# CITY OF ALBUQUERQUE

September 28, 2018

**Re: Bob's Burger Drive thru Restaurant**  
**5307 4<sup>th</sup> street N.W. ALB NM 87107**  
**Traffic Circulation Layout**  
Engineer's/Architect's Stamp **XX-XX-XX** (F14-D036)

AS-101

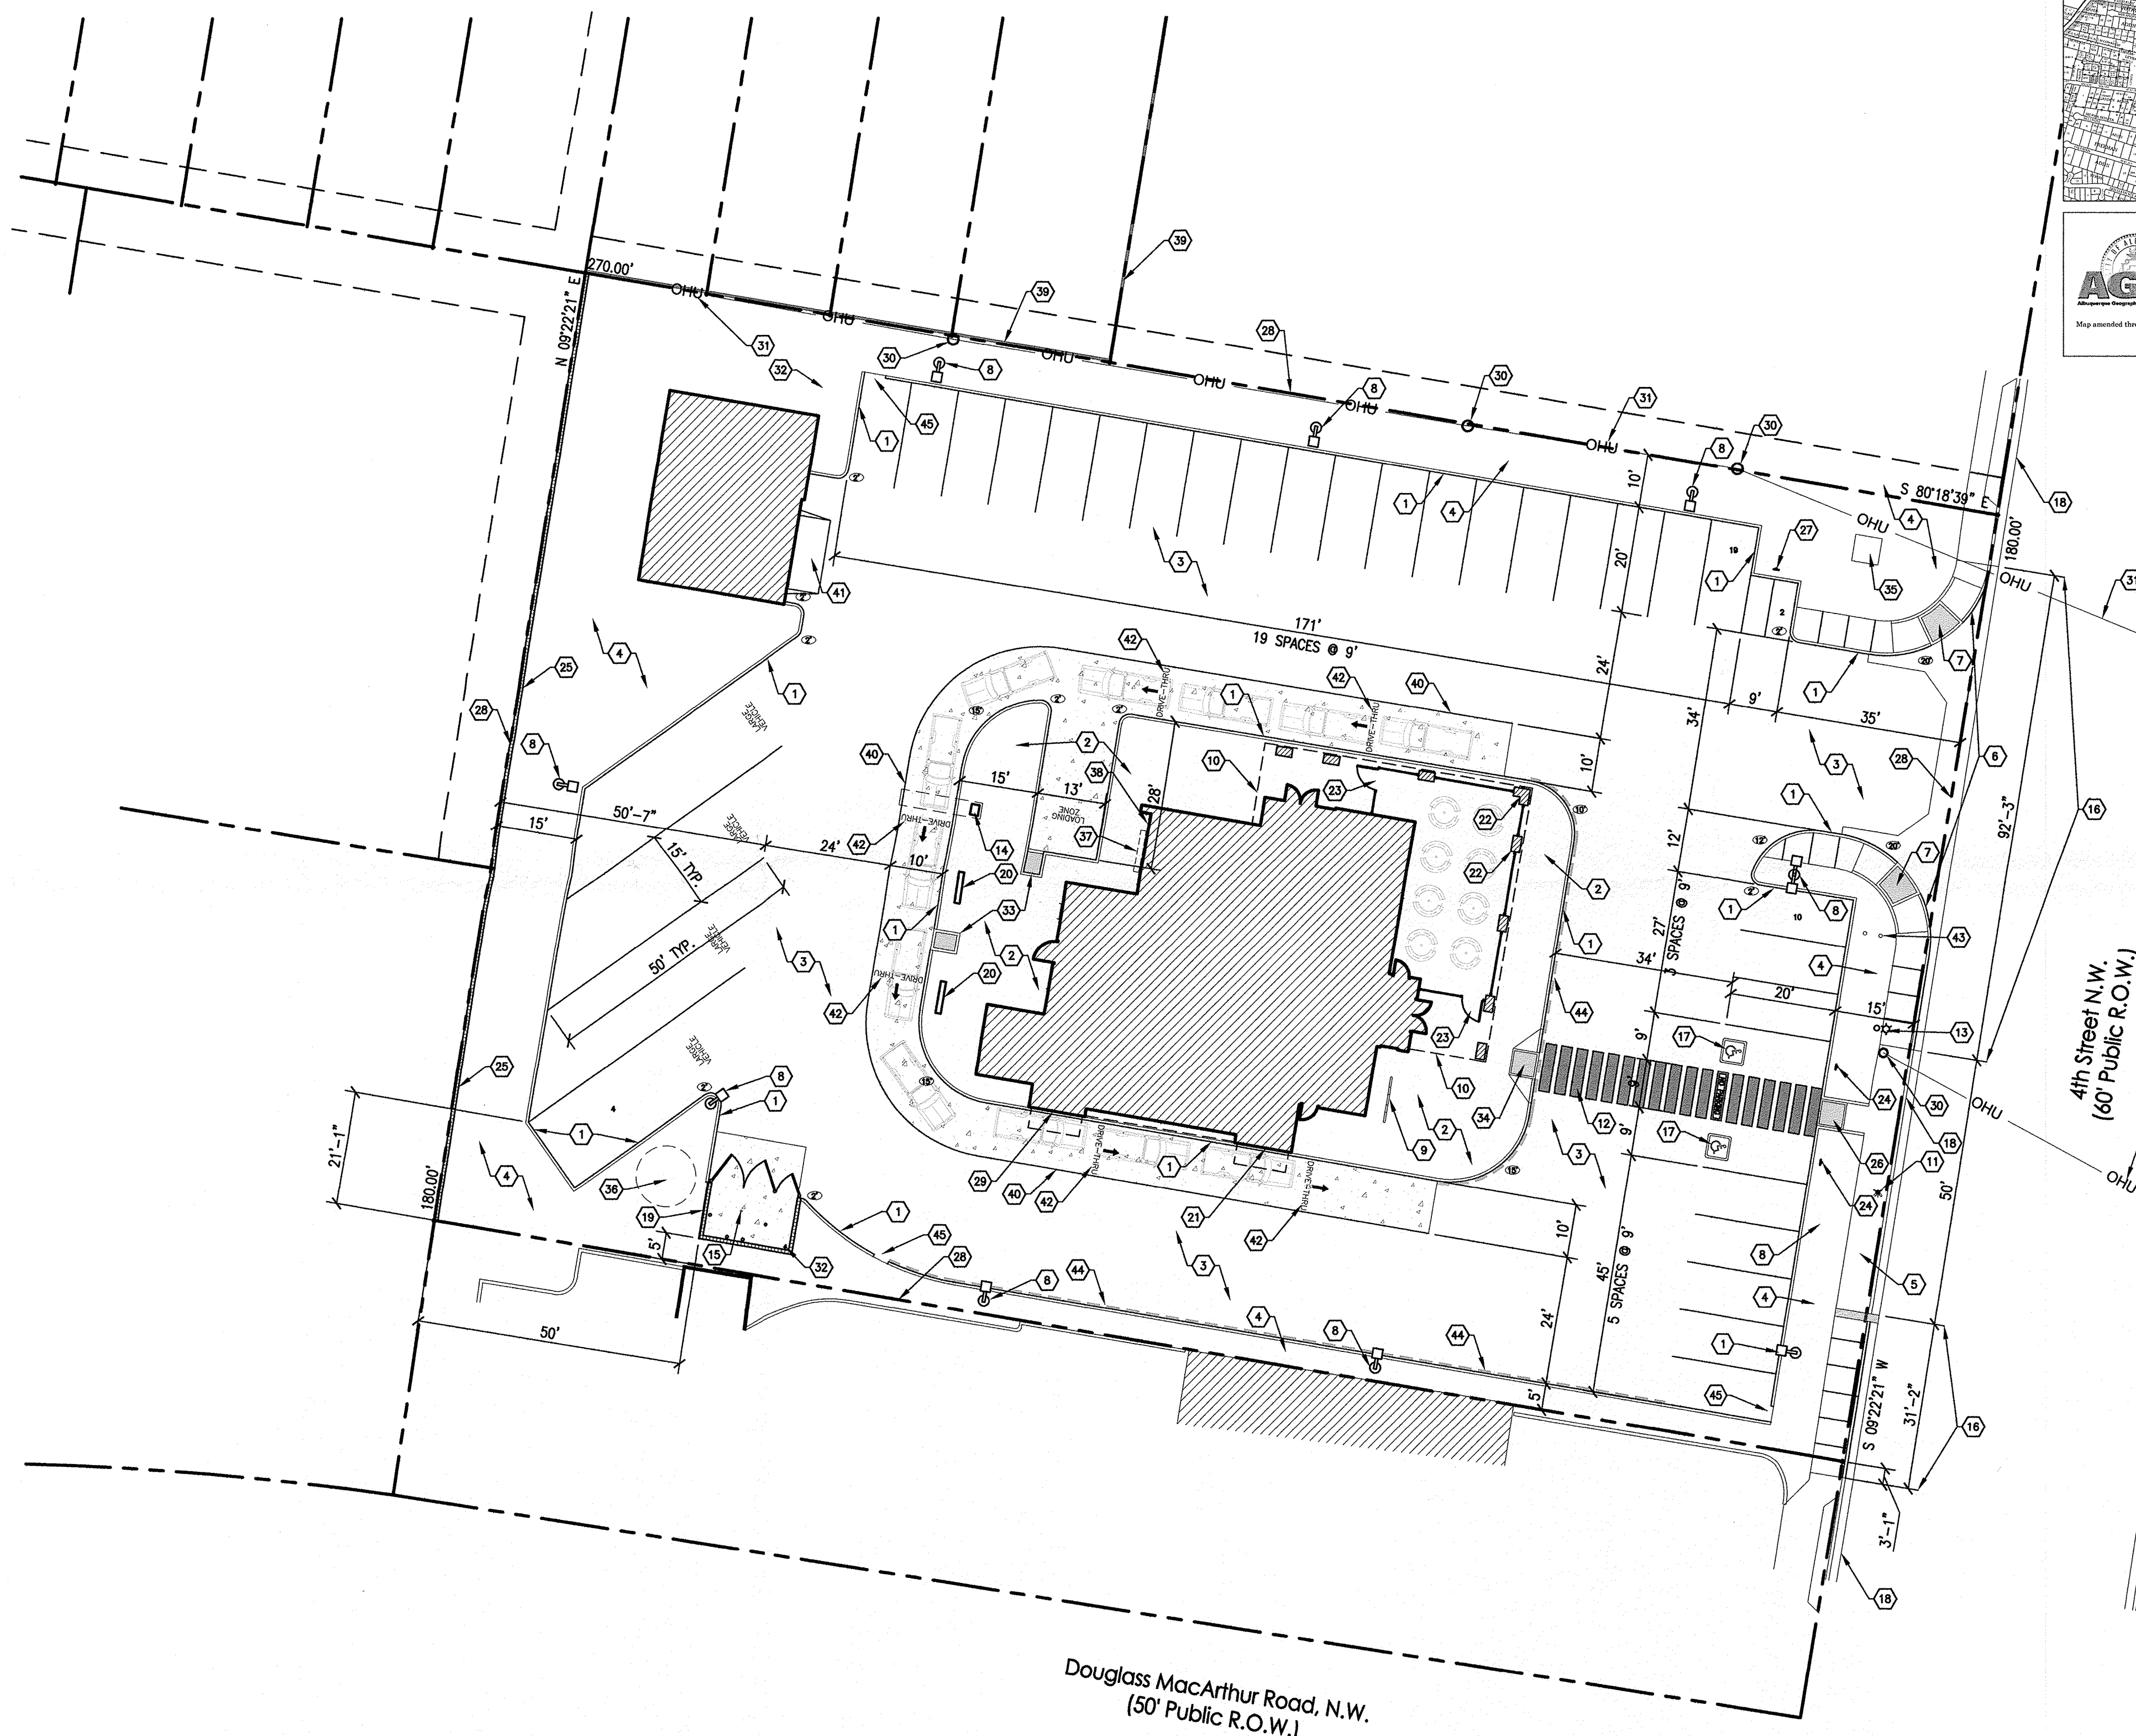
1. Please show a vicinity map showing the location of the development in relation to streets and well known landmarks.
2. The traffic circulation layout must be stamped, signed, and dated by an engineer or architect licensed in the state of New Mexico.

3. The ADA accessible parking sign must have the required language per 66-7-352.4C NMSA 1978 **"Violators Are Subject to a Fine and/or Towing."** Please call out detail and location of HC signs.

4. The ADA access aisles shall have the words **"NO PARKING"** in capital letters, each of which shall be at least one foot high and at least two inches wide, placed at the rear of the parking space so as to be close to where an adjacent vehicle's rear tire would be placed. (66-1-4.1.B NMSA 1978)

5. Please show an upright sign on a detailed sheet.
6. ADA accessible pedestrian pathway should not be placed behind parking space or adjacent to a vehicular way. Vehicle and pedestrian/wheel chair conflicts should be avoided as much as possible.

7. All sidewalks along streets should be placed at the property line.
8. The minimum drive through lane width is 12 feet with a 25 foot minimum radius (inside edge) for all turns. (A 15 foot radius can be used with an increase in lane width to 14 feet). Please dimension all lane widths and radii.

9. Submit all the detailed sheet as mentioned in keyed notes.
10. Some of the items on the keyed notes are not visible on the plan, please clarify:#22, 23, 24, 26, 35,... etc

11. ADA curb ramps must be updated to current standards and have truncated domes installed
